M25 junction 28 improvement scheme

TR010029

9.84 Applicant's comments on Transport for London's response to ExAWQ2

April 2021

Client		Project		GROVE FARM ACCESS, JUNCTION 28 M25 NORTHBOUND SLIP LANE	
MR L JONES & MRS K JONES		Title		ACCESS ALTERATIONS TO GROVE FARM	
Status	Drawn	Scale	Sheet Size	Date	Drawing No.
FOR APPROVAL	PL	1:1000	A3	JAN 2021	REDW-3396-110
				Rev

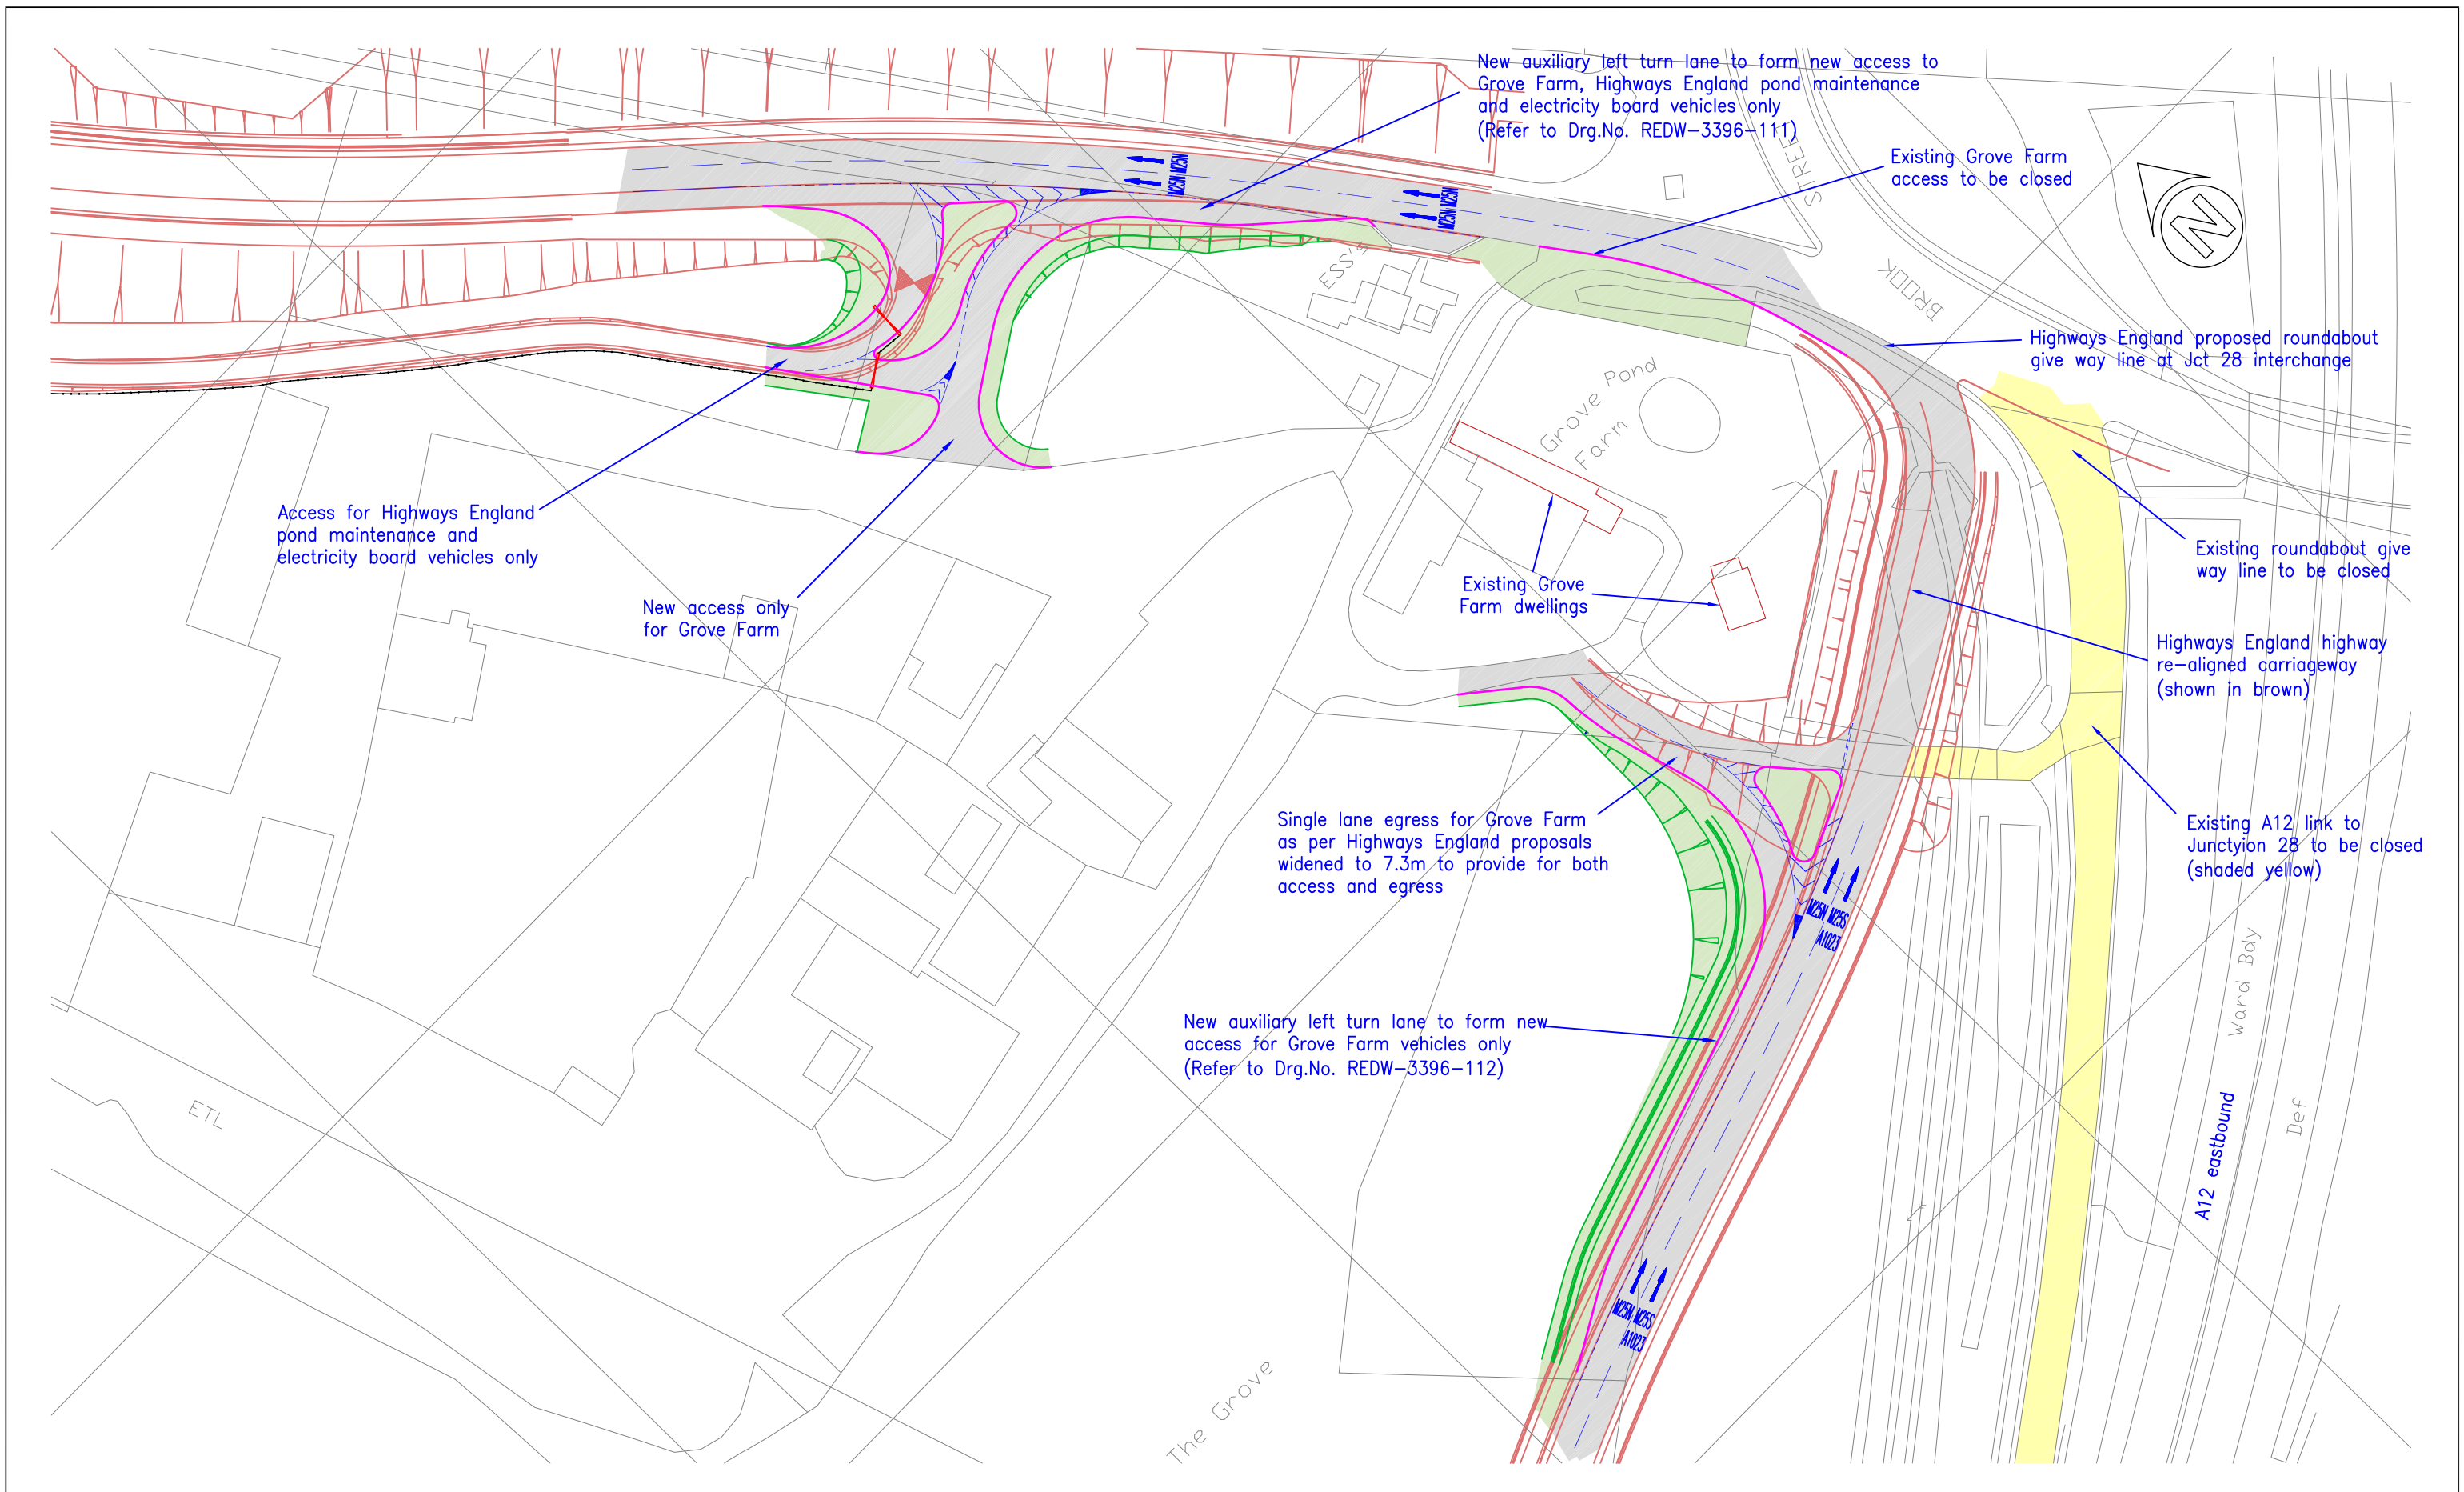
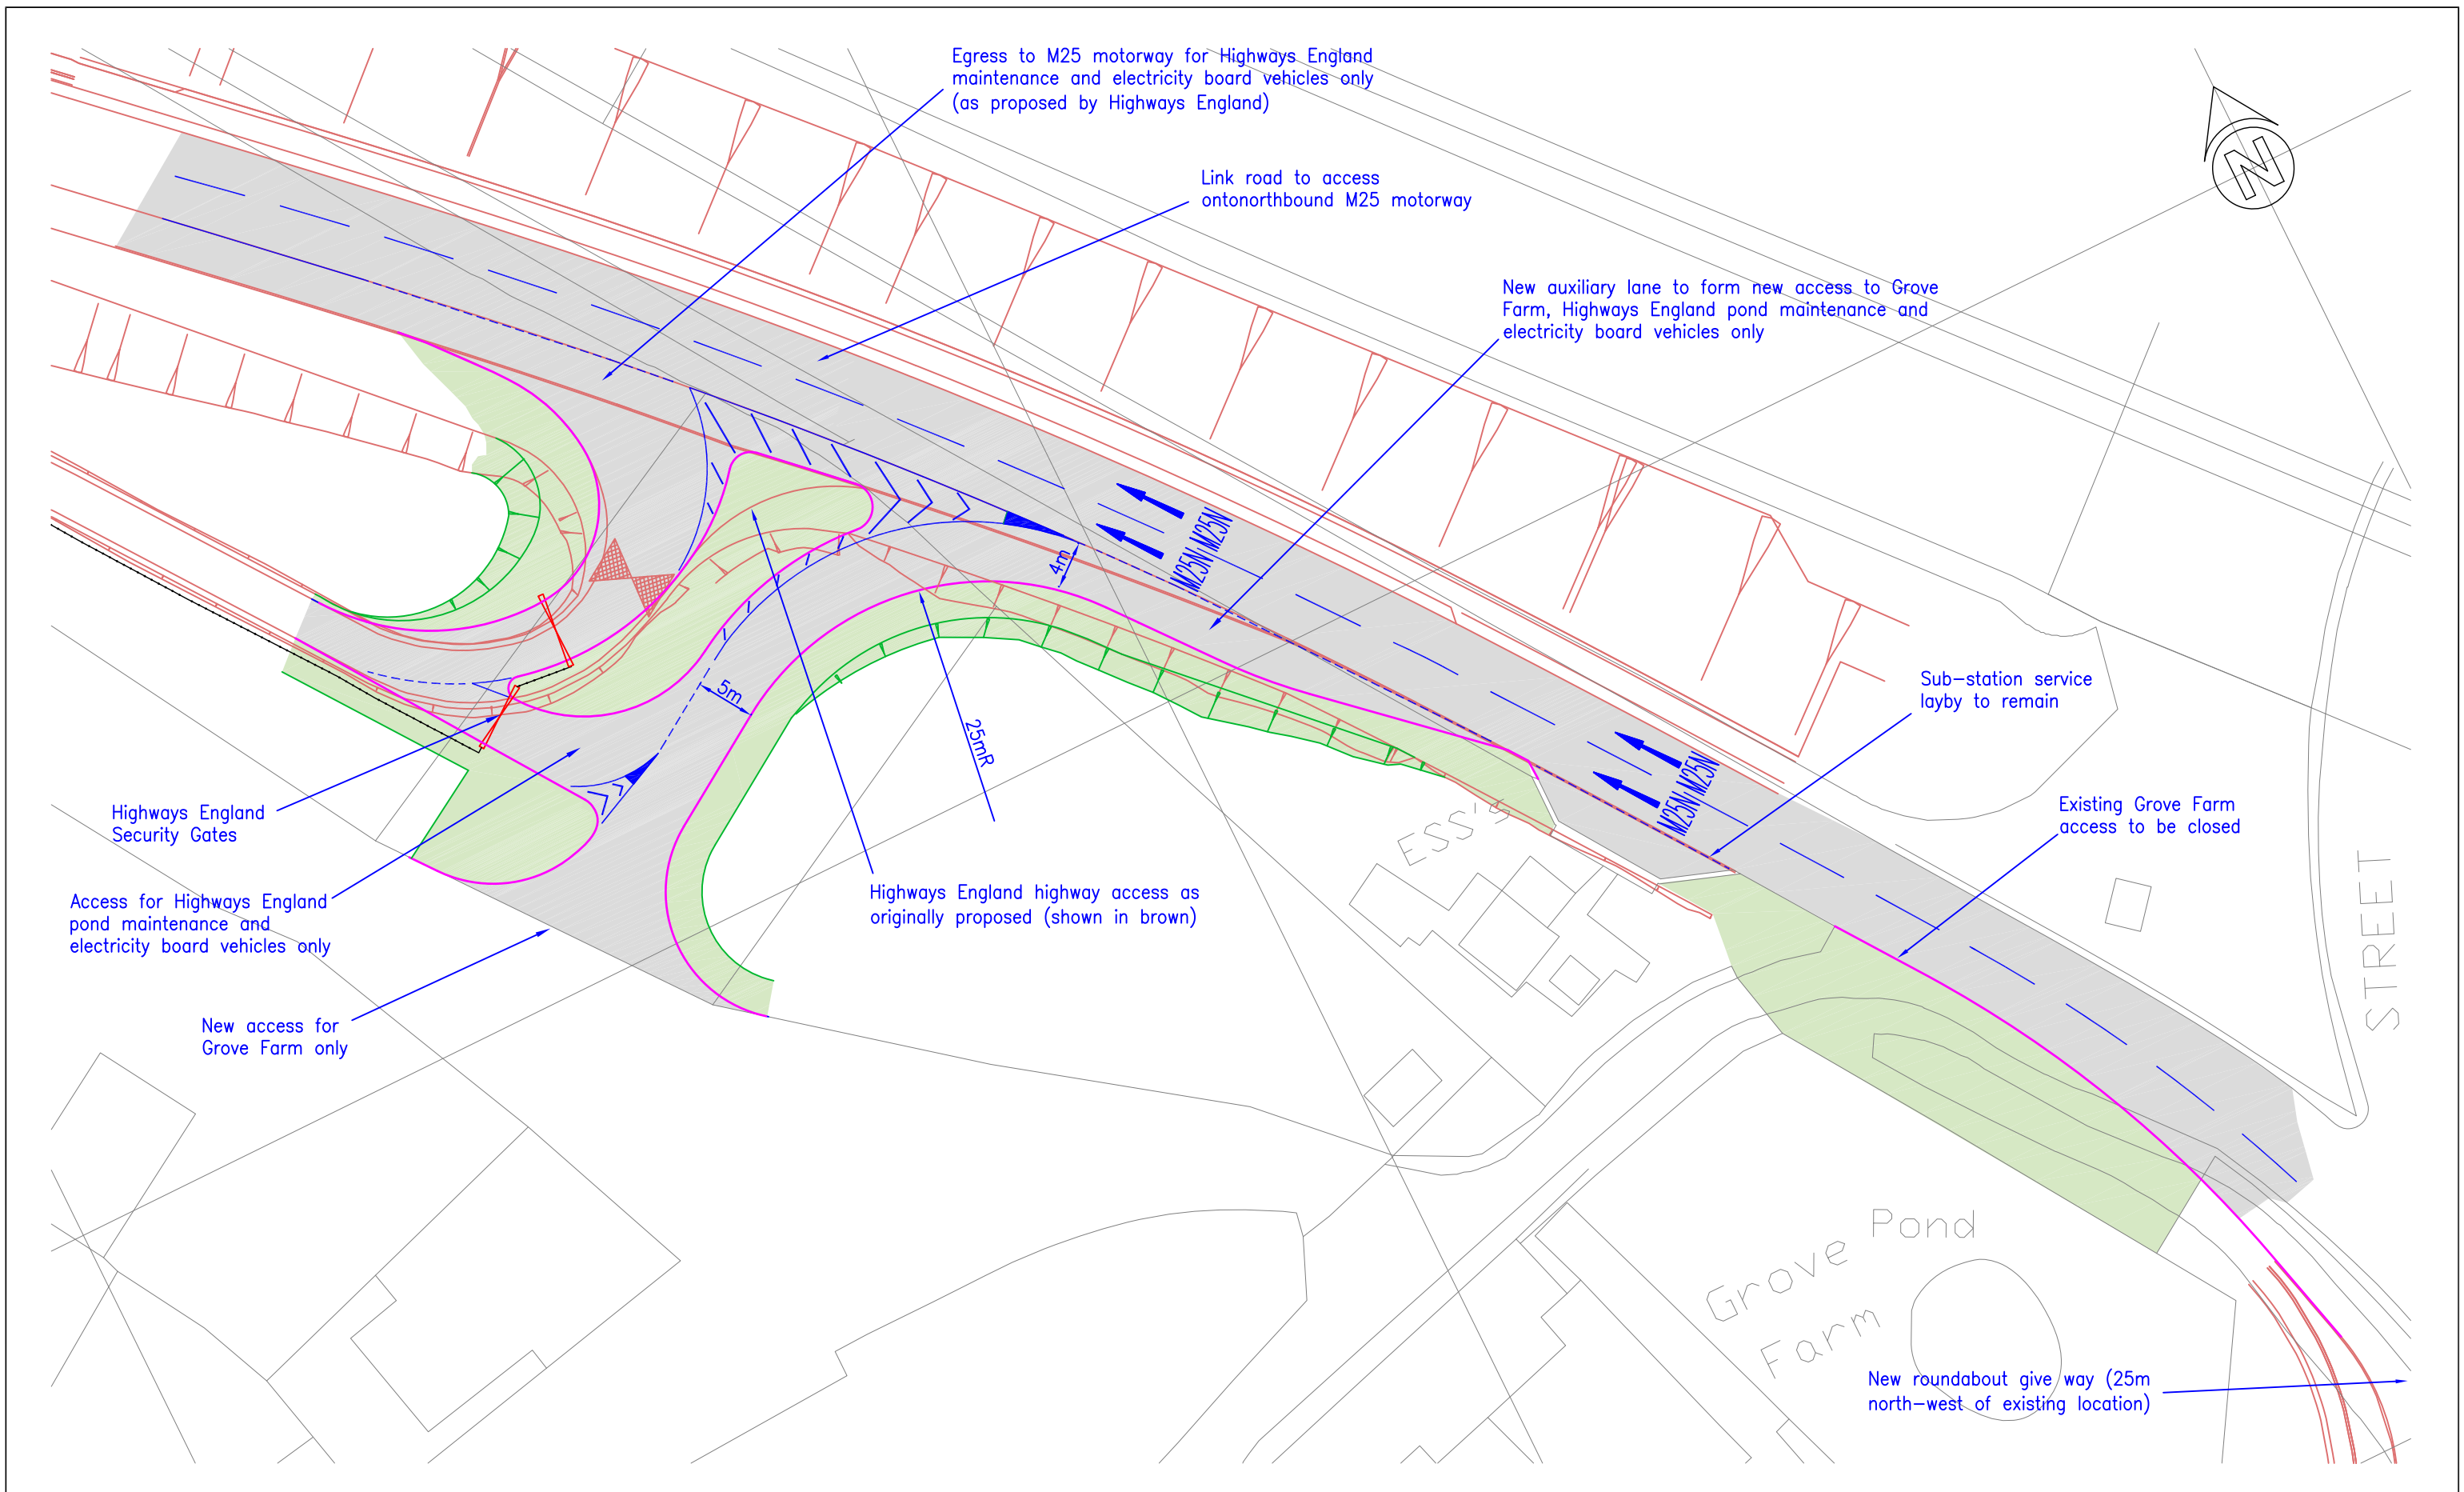
TA 2.3 Proposed Access / Egress at Grove Farm The Applicant Transport for London London Borough of Havering	The representatives of Mr & Mrs Jones submitted revised proposals at Deadline 4 [REP4-036] for access / egress to and from their property. Provide comments on these proposals.	TfL has reviewed the proposed new Location for the egress from Grove Farm onto the new A12 eastbound off slip road set out in the plan in document REP4-036. This results in the egress being Located approximately 120 metres from the proposed stop Line at the roundabout instead of the current distance of approximately 70 metres, an increase of 50 metres. TfL has not identified any immediate safety concerns with this proposal when compared with the Layout currently proposed by the Applicant. It would be important to demonstrate that there is sufficient visibility to and from the new egress Location for the required design speed. The alternative egress Location may require a new or revised departure from standards. TfL is not able to comment on the proposal in terms of construction feasibility or environmental impacts and we would expect the Applicant to consider these alongside a full assessment of road safety implications.	Noted
